**STATEMENT ON BEHALF OF
CHELTENHAM BOROUGH COUNCIL
FINANCE & ASSETS**

**OBERVATIONS ON
M5 J10 IMPROVEMENTS
DRAFT DEVELOPMENT CONSENT ORDER**

Barn Farm, Stanboro Lane

ENVIRONMENTAL MASTER PLAN SHEET 01 OF 16

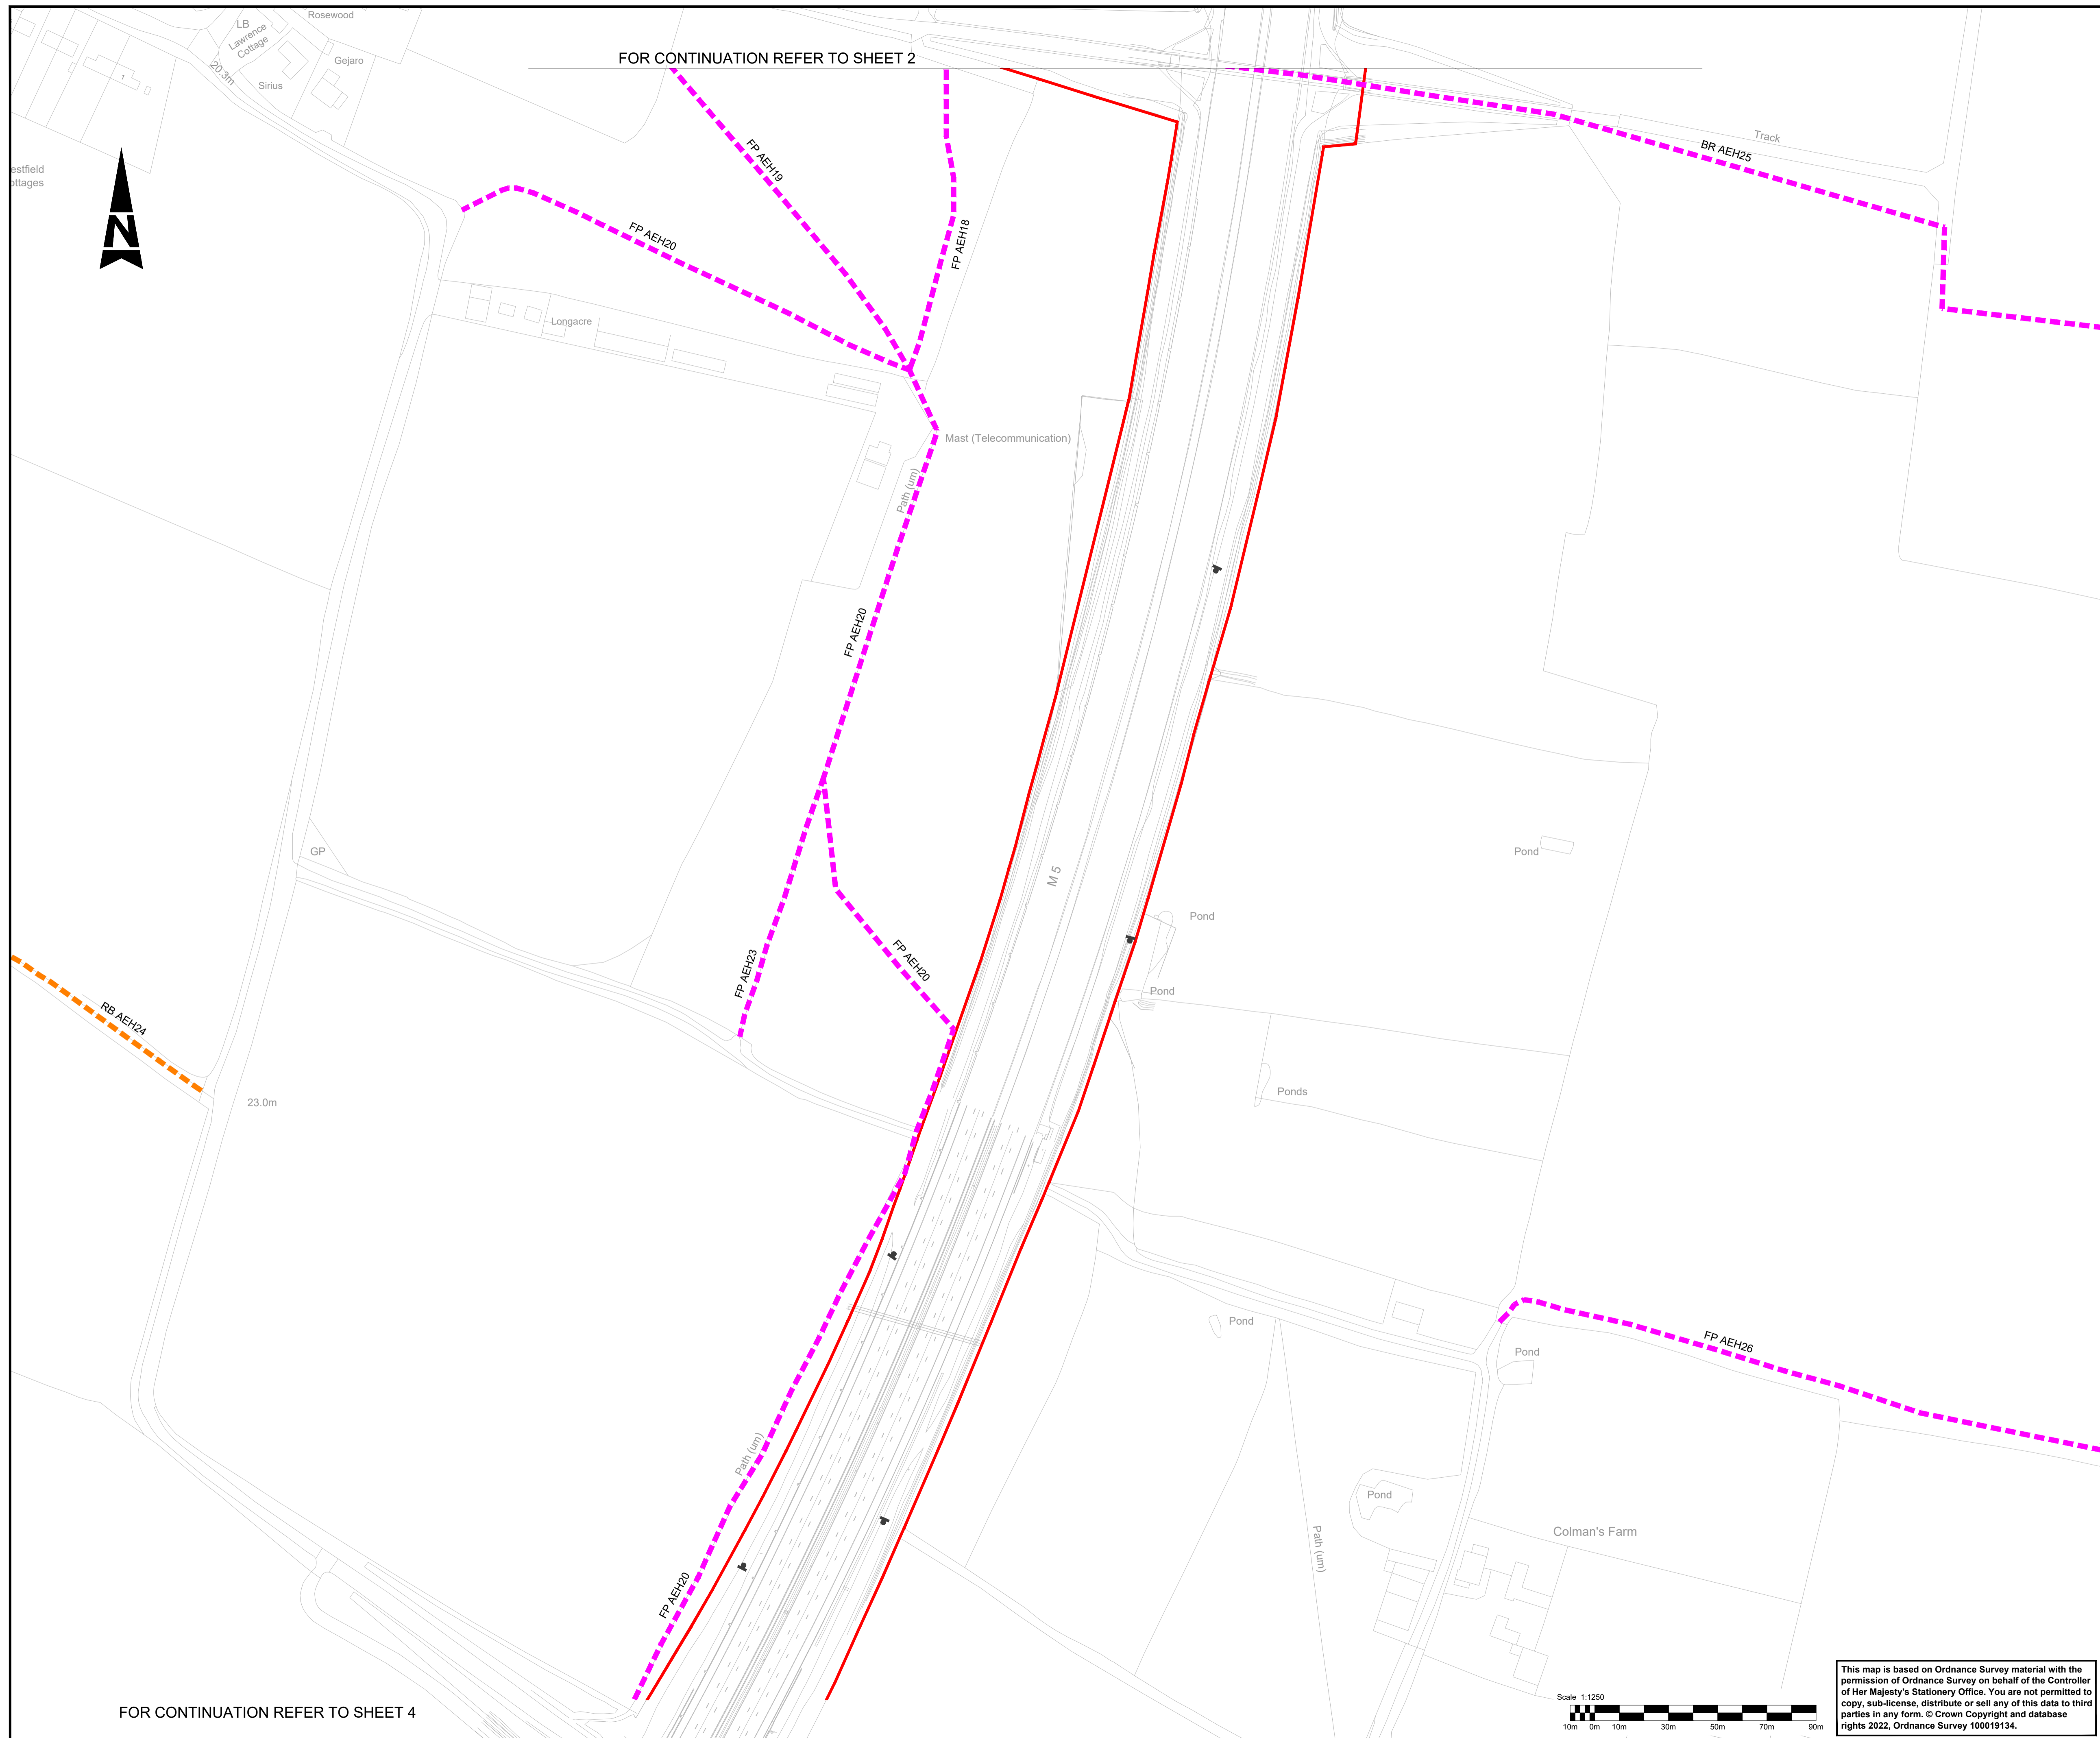
5.1.1 As part of the junction improvement scheme, an attenuation pond is proposed on land to the immediate north west of Stanboro Lane, within CBC Finance & Assets land, as shown below.

5.1.2 This attenuation pond would restrict the ability to provide a suitable junction to serve the recycling centre or strategy residential / employment development on the Barn Farm site in the future.

5.1.4 PEP has looked at the Barn Farm site access proposals alongside the attenuation pond and indicate below an alternative option to relocate the pond to the east within the DCO boundary and CBC Finance & Assets land. This is considered feasible in principle.

- 6.1.3 A junction to Barn Farm is achievable in principle with the new J10 improvements, but attenuation basin 1 proposed would make it difficult to provide a new junction at an appropriate standard to serve any potential waste / recycling or strategic development at the Barn Farm site in the future.

- 6.1.4 This Note has provided an alternative area to locate the attenuation pond that would maintain sufficient land to provide an access to the Barn Farm site. In principle a relocated attenuation pond 1 to the east could continue to serve the necessary drainage function.
